**Buronga Landfill Expansion (SSD-10096818)
Response to Submissions (RtS)**

Attachment 1

Department of Planning and Environment - comments on Buronga Landfill Expansion EIS – April 2022

NOT FOR CONSTRUCTION
WENTWORTH SHIRE COUNCIL
BURONGA LANDFILL EXPANSION
FIGURE 9
PROPOSED STAGES AND SUBSTAGES LAYOUT
FILENAME: 202597 CONCEPT DESIGN.DWG
PROJECT NUMBER 202597
DRAWING NUMBER 011
REVISION B

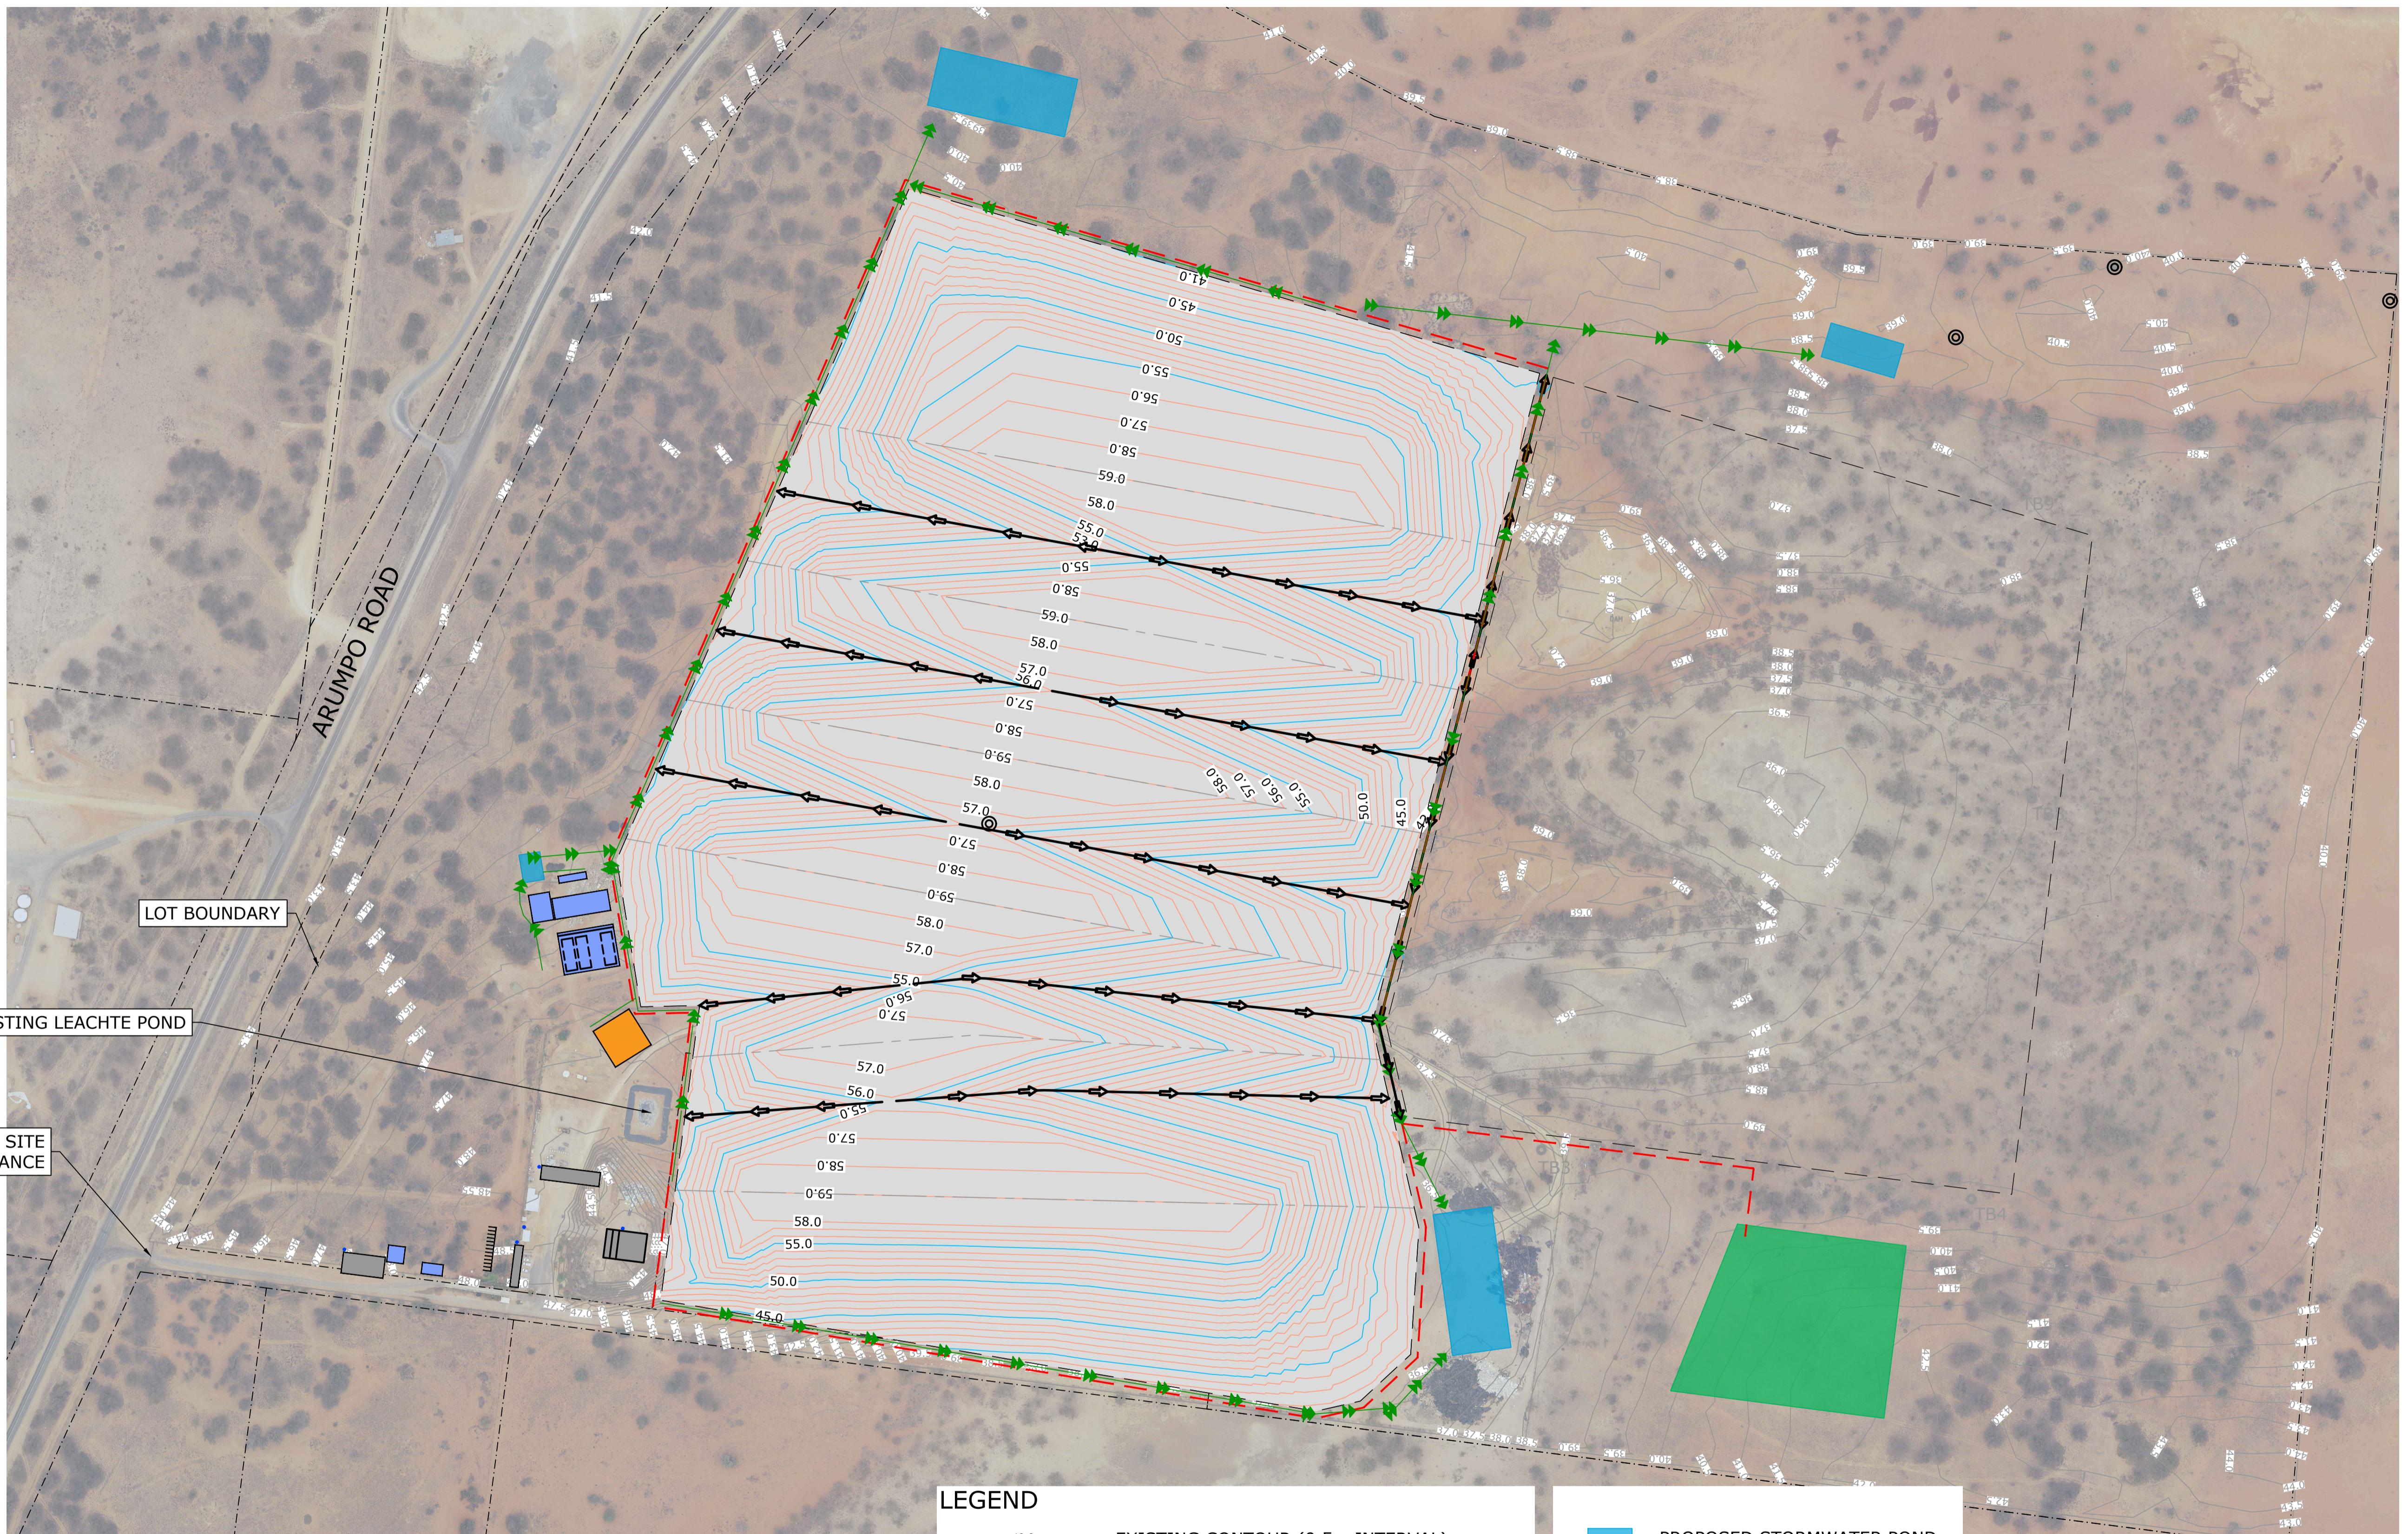
- Amended drainage plan showing drainage lines consistent with the north-south orientation of Stage 2 landfill cells
- Details of how the new landfill cells in Stage 1 would connect to the existing leachate pond, which would be used until such time as the new leachate pond and service alignment are constructed
- Details of the capacity of the existing leachate pond, including approximate service life remaining and likely timing of the construction and use of the proposed new leachate pond and service connections

- Visual assessment from key sightlines with diagrammatic representation of views to proposed structures and Stage 1 and Stage 2 rehabilitated dunes
- Explanation of the north-south orientation of the Stage 2 cells being at right angles to the east-west orientation of the Stage 1 cells which are said to be sympathetic to other regional landforms (EIS pp. 51 & 68-69)
